**MONUMENT SERVICE UPGRADE**  
20021 BEACON LITE RD, MONUMENT, CO 80132

MONUMENT SERVICE UPGRADE  
 20021 BEACON LITE ROAD  
 MONUMENT, COLORADO

1 SITE / FLOOR PLAN
 A1.0 SCALE: 1" = 10'-0"

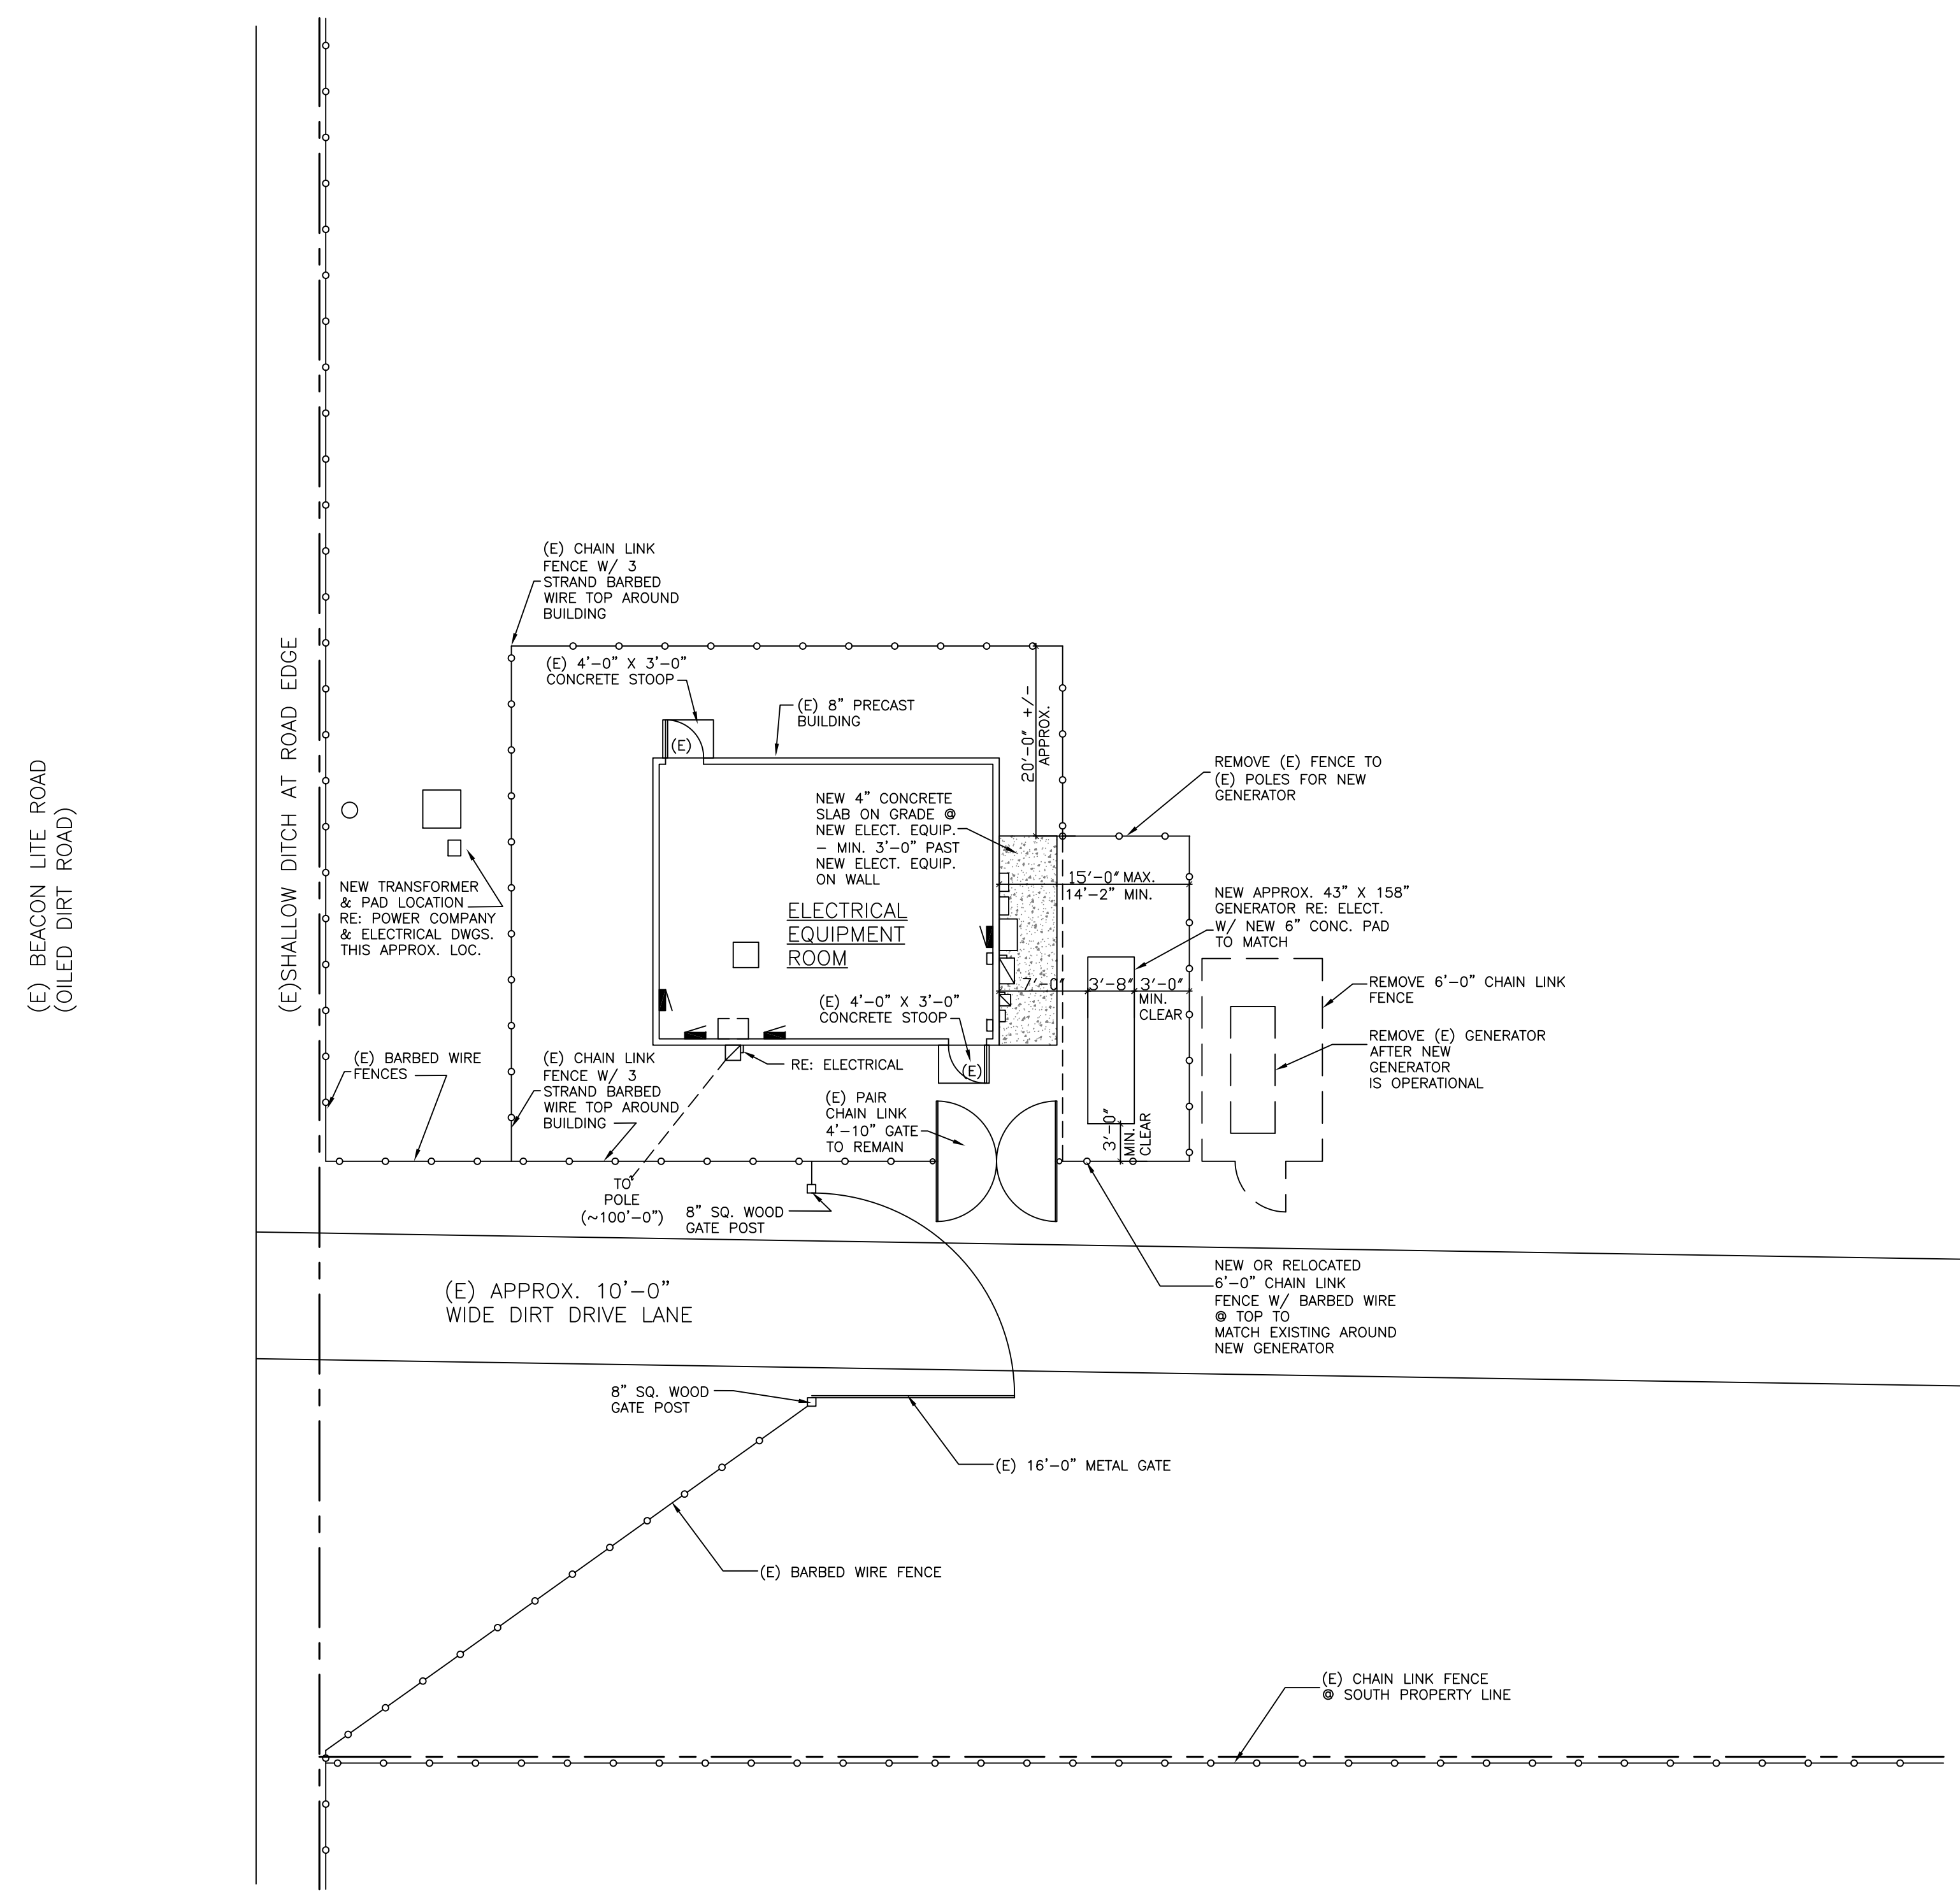
All property boundaries should be shown on the site plan. All dimensions from the property line to improvements should be shown.

1 LANDSCAPE PLAN
L1.0 SCALE: 1" = 10'-0"

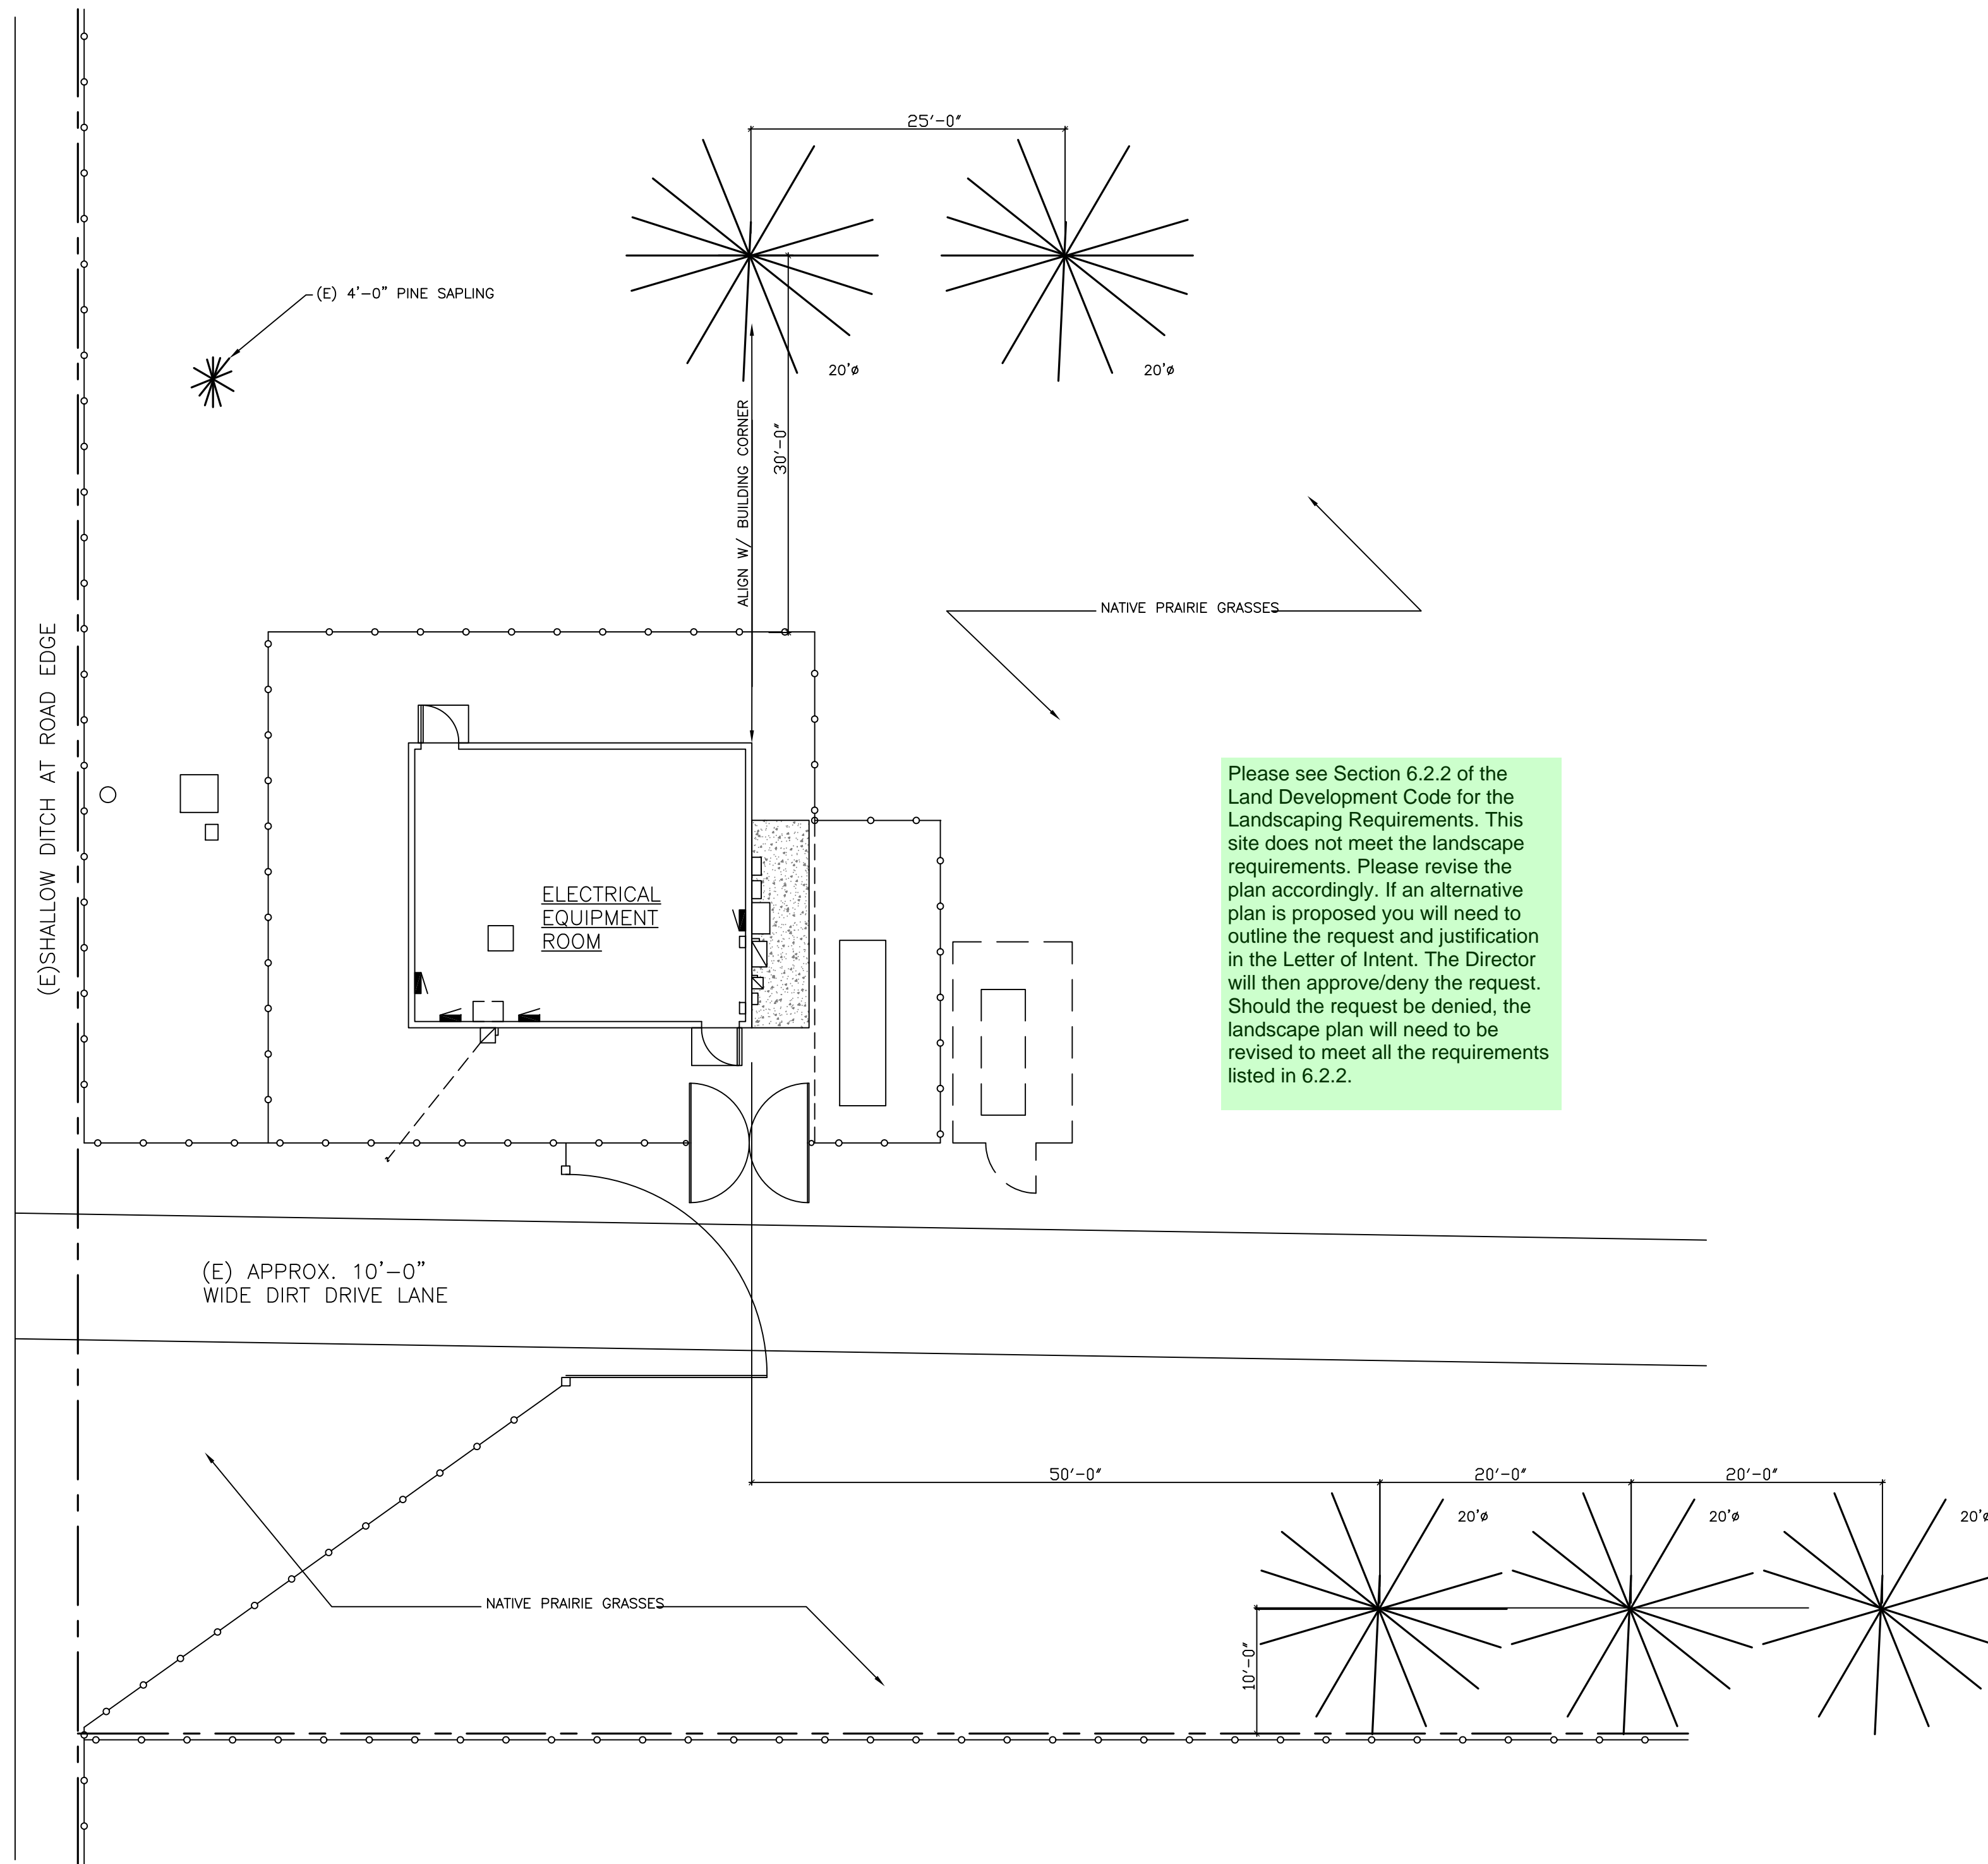
Please see Section 6.2.2 of the Land Development Code for the Landscaping Requirements. This site does not meet the landscape requirements. Please revise the plan accordingly. If an alternative plan is proposed you will need to outline the request and justification in the Letter of Intent. The Director will then approve/deny the request. Should the request be denied, the landscape plan will need to be revised to meet all the requirements listed in 6.2.2.
